**From:**  
**Sent:** 22 July 2026 16:39  
**To:** Katie Chew  
**Cc:** DC Admin  
**Subject:** Planning Application 2026/91657 - Comment - Apparent Eastward Extension of Plot 23 and Reduced Separation from No. 92

Rev B	03/06/2026	Updated for planning submission.		
Rev A	24/09/2025	Minor amendments, dimensions added.		
Project :		Housing at Lingards Road, Slaithwaite.		
Client :		SB Homes.		
Drawing :		Plot 23 - OPTION 1.		
Scale :		1:100.	Date :	May 2025
Dwg No :		2019 572 Sk 15	Rev :	B

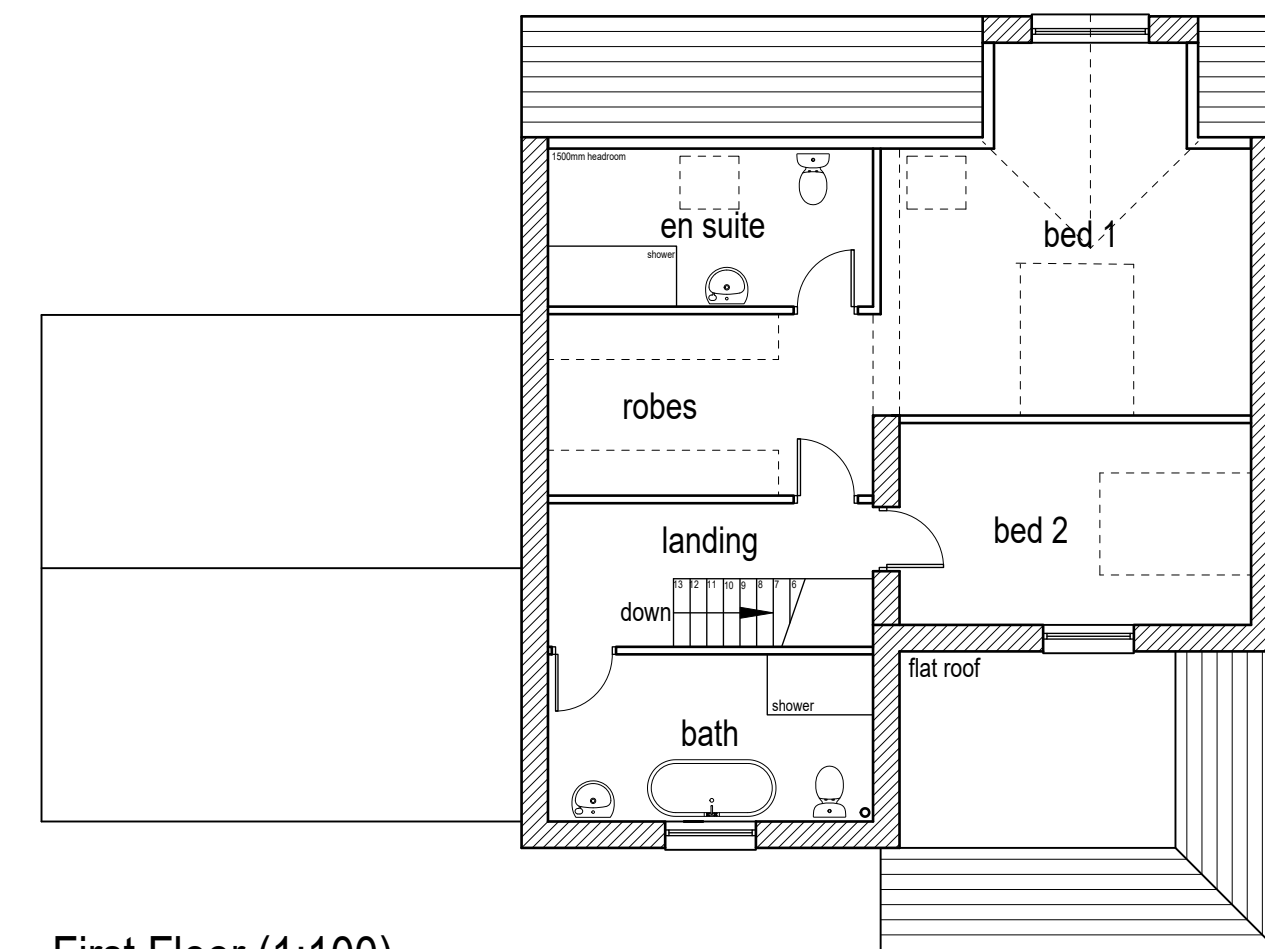
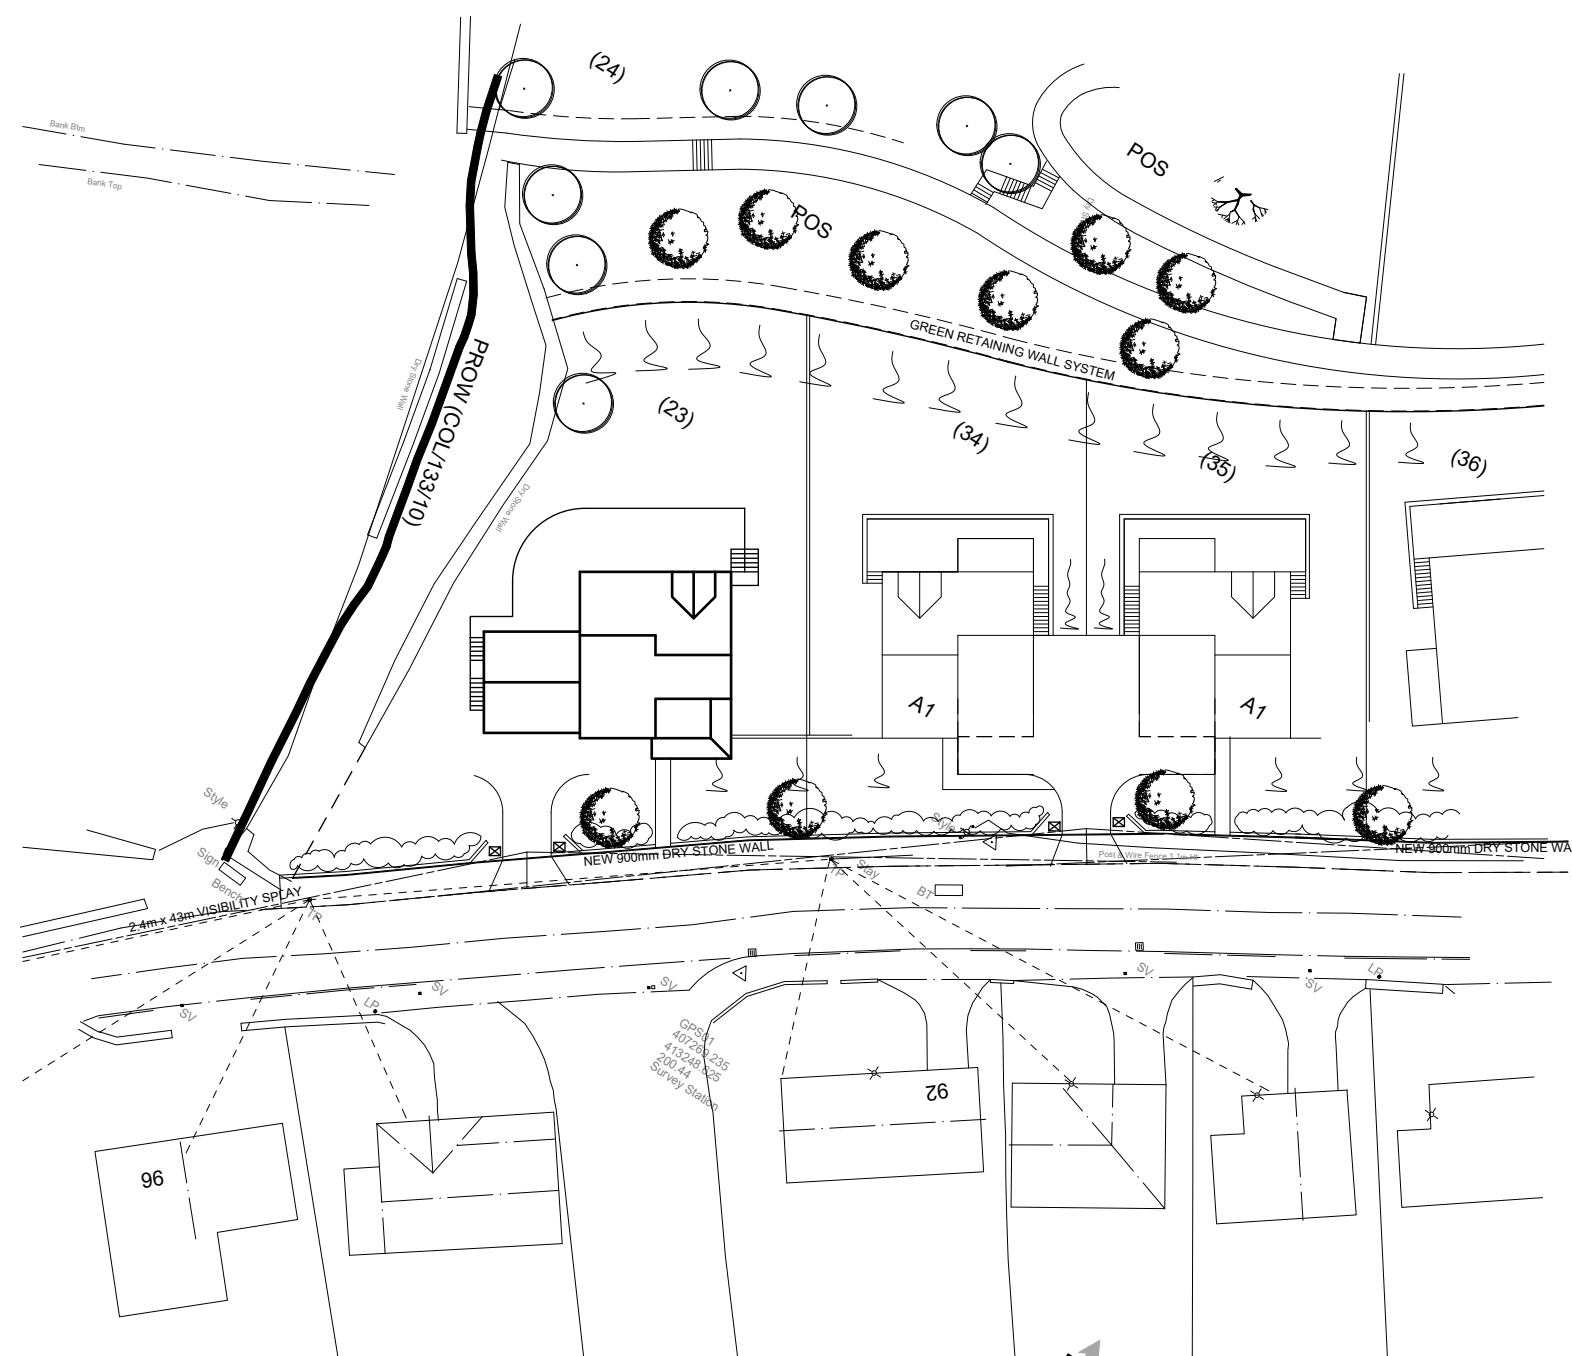
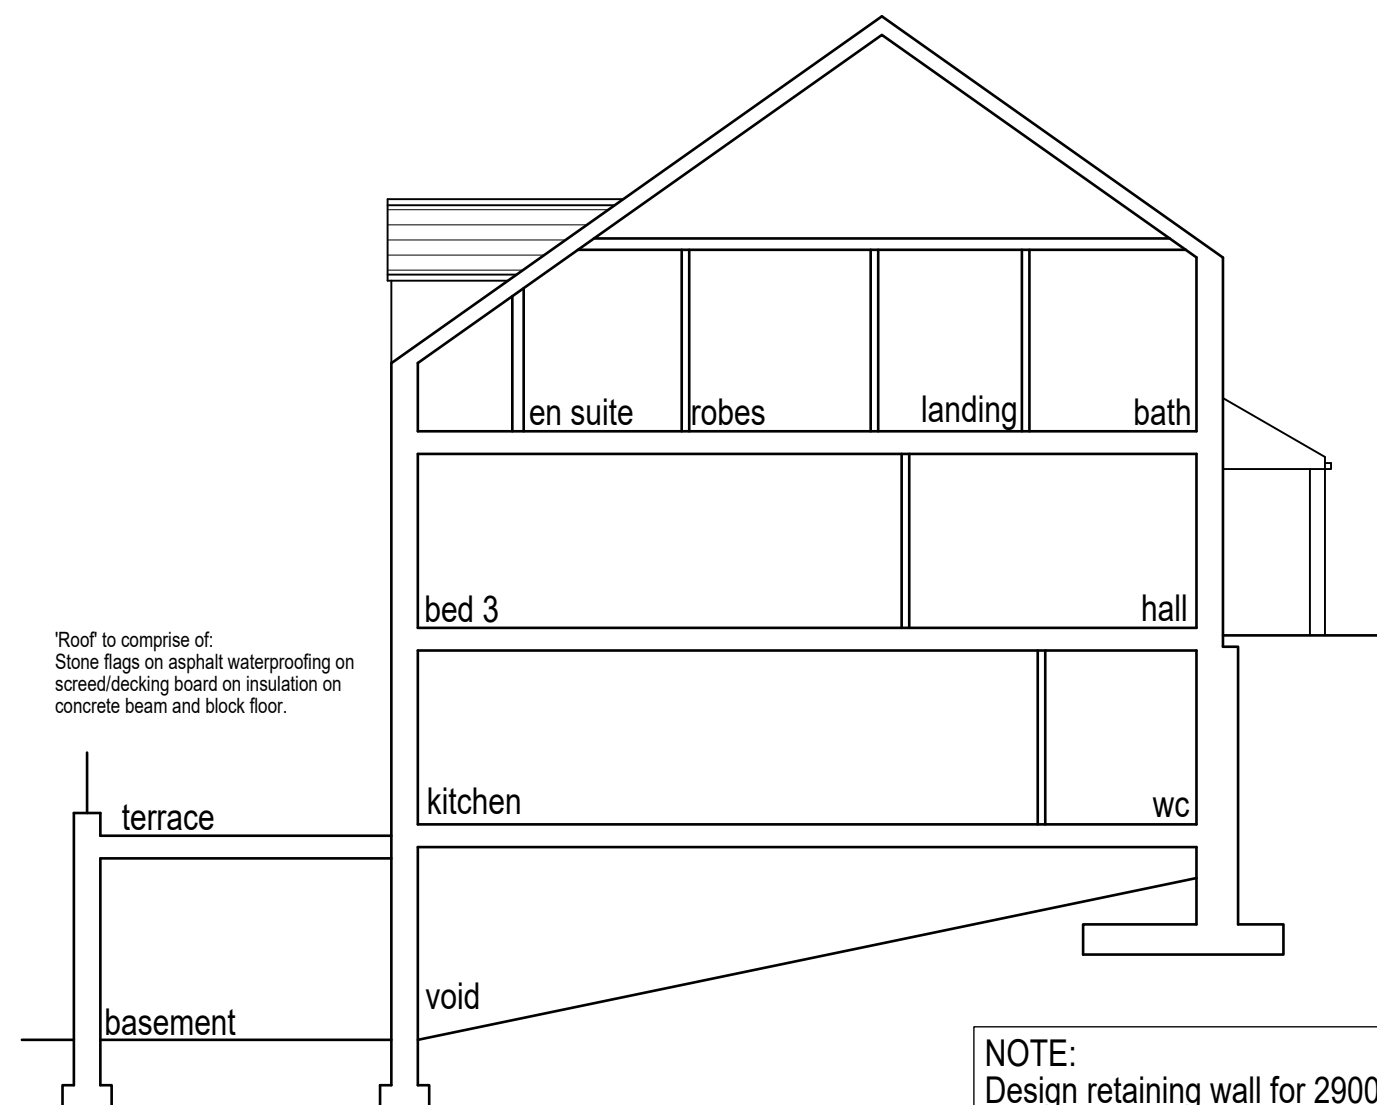
I wish to raise a further objection concerning an apparent discrepancy between the dimensions of Plot 23 shown on the site/layout plans and those shown on the detailed house-type plans and elevations.

The site/layout plans show the overall width of Plot 23 as approximately 1 metre less than the width shown on the detailed floor plans and elevations for the same dwelling.

The front elevation has also been measured on site, insofar as reasonably possible, and appears to correspond with the greater width shown on the detailed house-type drawings rather than the shorter footprint represented on the site/layout plan.

If the western side of the foundations was set out in the position shown on the layout plan, the additional approximately 1 metre of built width must extend from the eastern side of the dwelling. The eastern elevation—and therefore the veranda positioned at the front/eastern corner—would consequently be approximately 1 metre farther east than represented on the site/layout plan.

However, that measurement uses the shorter Plot 23 footprint shown on the layout plan. It does not account for the additional width shown on the detailed plans and apparently constructed on site.

Because the eastward extension is oblique to the shortest line between the veranda and No. 92, the separation would not reduce by the full 1 metre. Based upon the orientation of the two properties shown on the plan, the component of the additional width directed towards No. 92 is estimated to be approximately **0.56 metres**.

Before application 2026/91657 is determined, the Council should reconcile the dimensional inconsistency between the site/layout plans and the detailed house-type drawings.
